Your Ref: OWPC21701
Our Ref: FG/6/19/PL 14-01-2019
Please ask for:
Andrew Wood

New dwelling
20 Rife Way Ferring

Thank you for your internet representation made on 12th March 2019 which has been recorded as '**an objection**' with the comments as follows:

SCALE 1:200 @ A3	DRAWING No. Site Plan
JOB No.

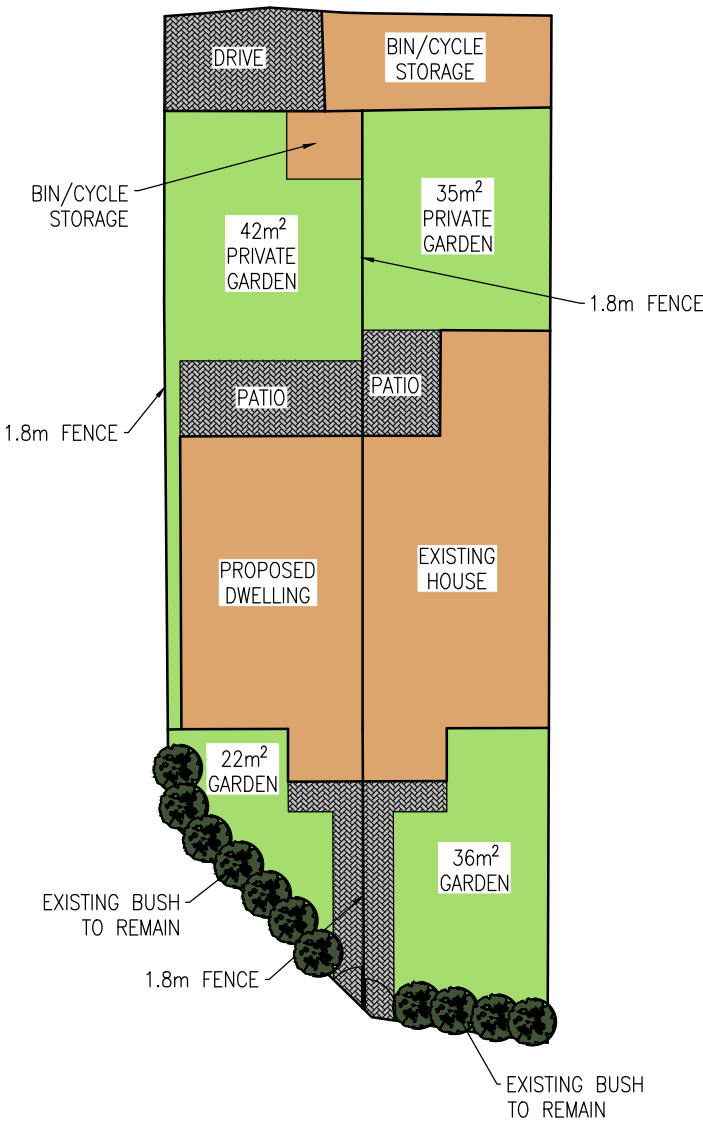
The lack of any parking provision, for either the existing house or the proposed additional house, is unacceptable. Meadow Way and Rife Way are already subject to heavy on-street parking and up to four additional vehicles wanting to park at or near this site, the junction of the two roads would cause real problems for traffic pedestrians and residents' amenity.

Drawing No.
Drawing 5
Proposed West
Elevation

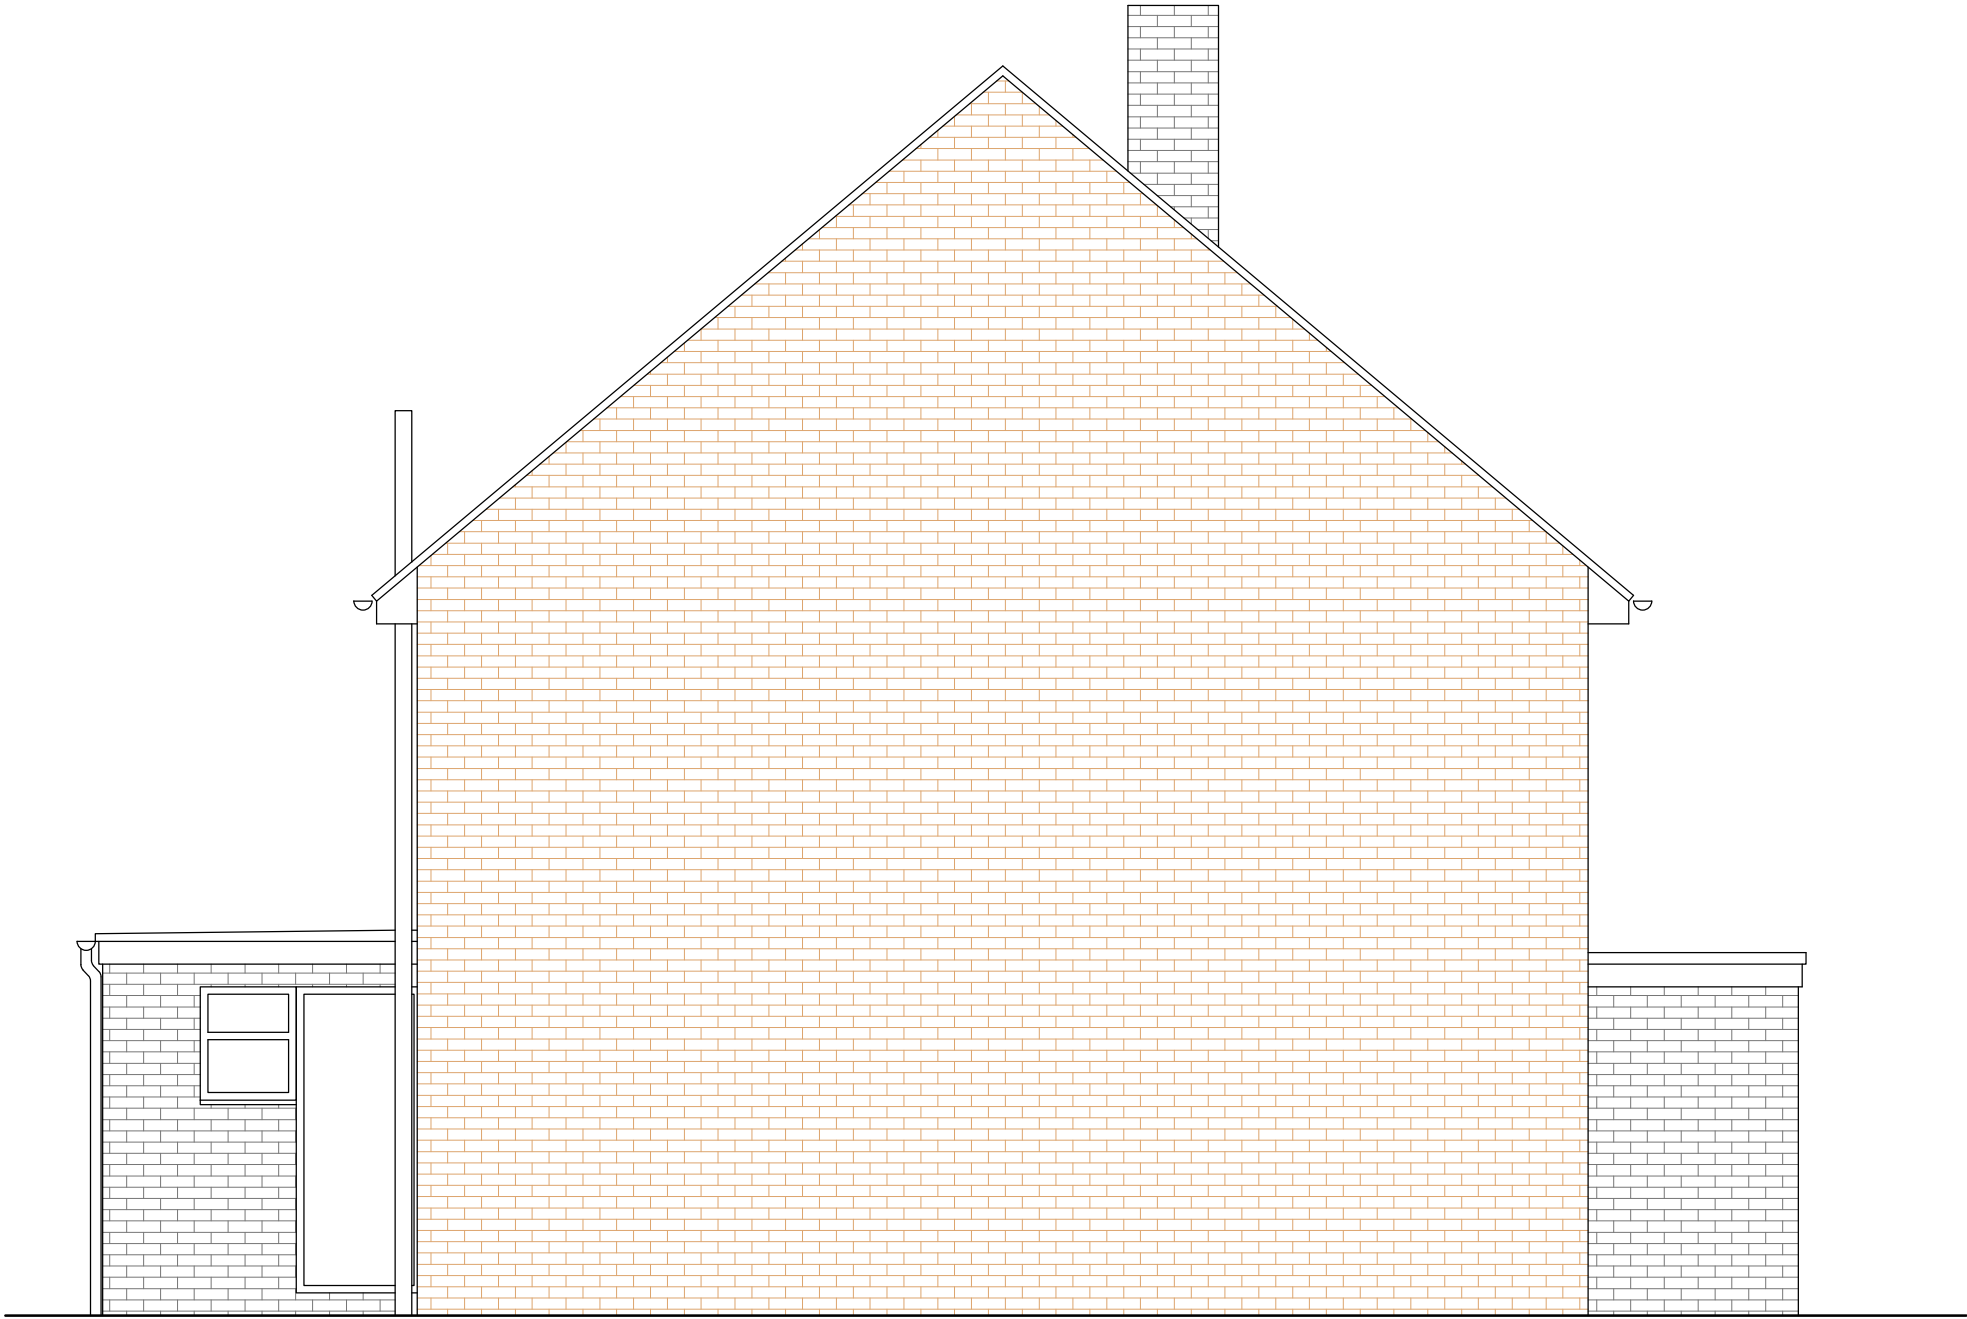
Ferring Conservation objects to this application to cram another house onto the site. The drawings supplied are not complete - they do not show the proposed West Elevation - which is presumably a blank wall- an unsightly addition to the street scene. The development would be cramped and unneighbourly.
